From: Michael Eastham
Sent: 07 December 2018 16:00
To: Planning.Responses
Subject: FW: AL/20/18/OUT - Land at Bridge Cottage and The Old Cottage, Lidsey Road, Lidsey

Please upload onto Ocella the email response below from the Local Highway Authority to the revised layout plans for AL/20/18/OUT.

I have received the following email and attachments from the applicant regarding AL/20/18/OUT. (*Response to highways junction plan*) – Drawing 1749-06 (overlaid with details from Reeves Transport Planning drawing OCL/SR/701 Rev. 'D') shows a revised road alignment and wider lane widths for the A29 where it passes the site. This plan does now show a clearer interpretation of the site access visibility splays which now appear to be achievable in-line with guidance based on the recorded traffic speeds. However, the Stopping Sight Distance(SSD)/forward visibility splays are still not shown properly and as such, it is not clear whether they can be achieved. Part of this is how the applicants/their agents have shown the positioning of the vehicle on the drawing waiting to turn into the site. However, it is also how the applicant/their consultants have plotted the splays (i.e. they appear to be

Project		
OLD COTTAGE LIDSEY		
New Access Design		
Drawn	Date	Scale (at A3)
TE	19/07/2018	1:500
Doc no.	Revision No.	
OCL/SR/701	C

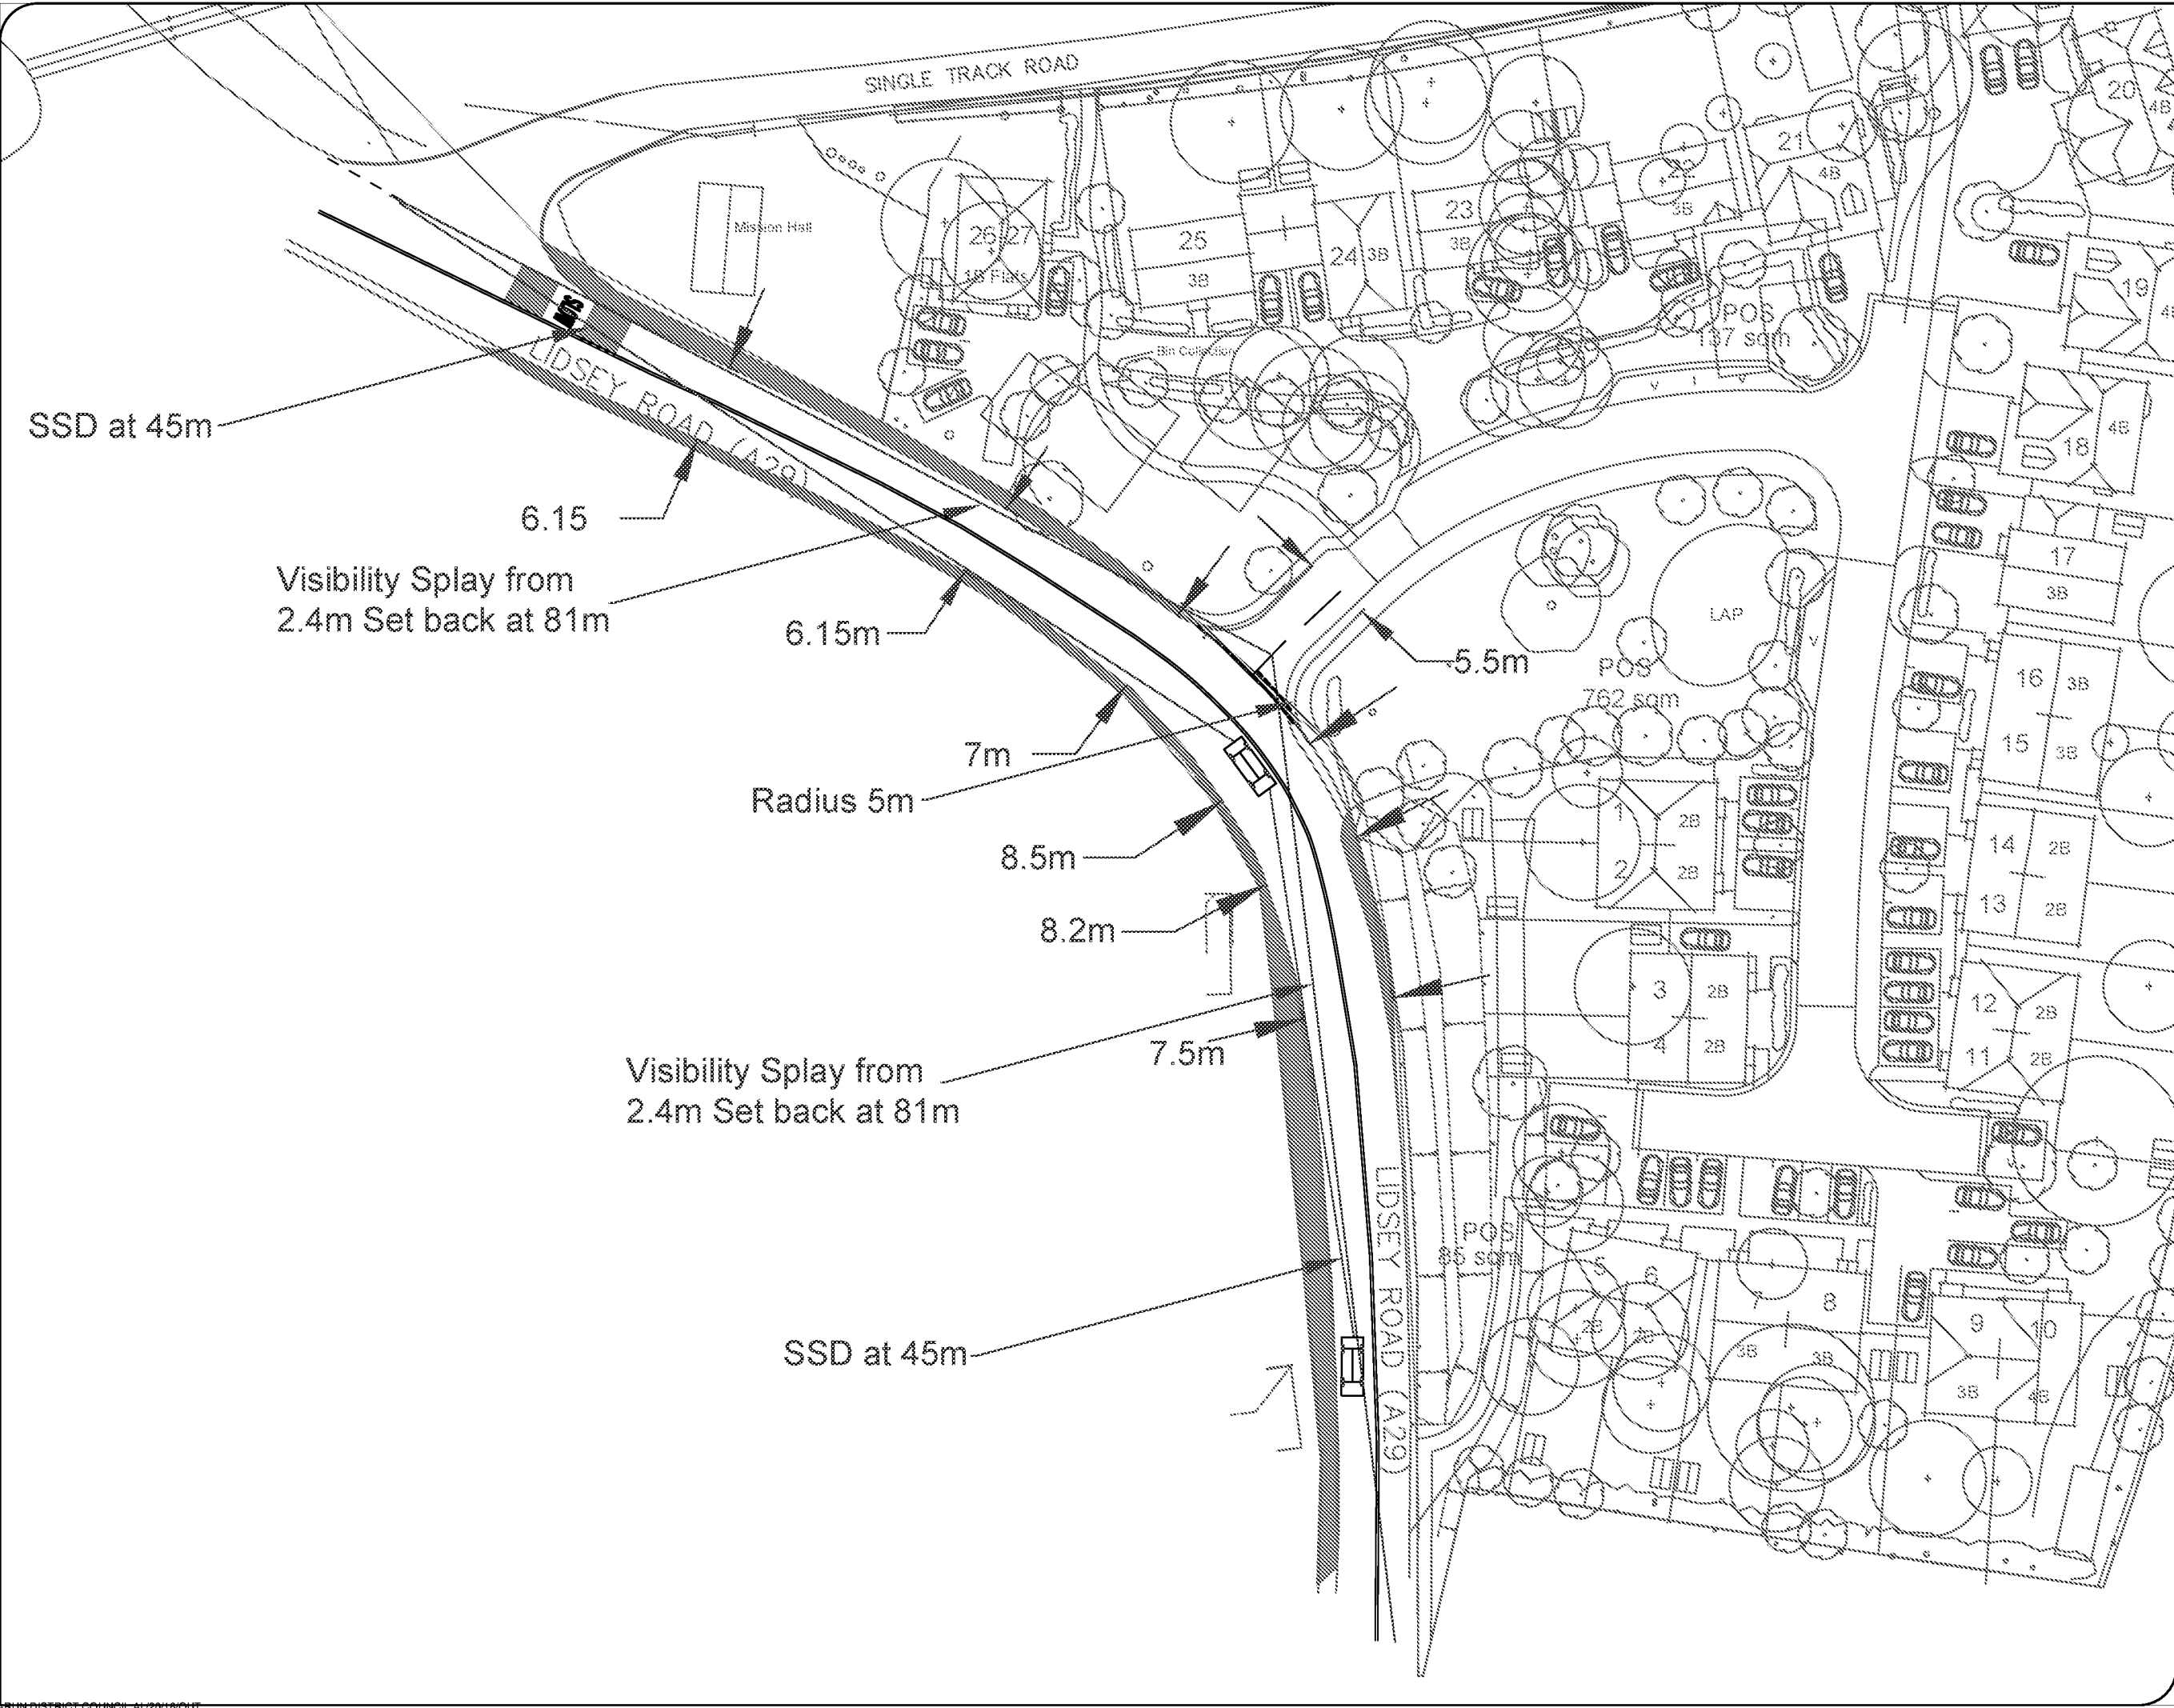
distances need to be plotted in both directions too. Therefore, it is not demonstrated that SSDs are achieved in both directions.

With regards to swept-path diagrams for vehicles using the A29 in proximity to the access, the only HGV tracking drawing provided so far is for a fixed-axle vehicle. Nothing has been provided for large articulated lorries nor buses using the road. Therefore, it is still not demonstrated that the proposed changes to the alignment and lane widths would be acceptable.
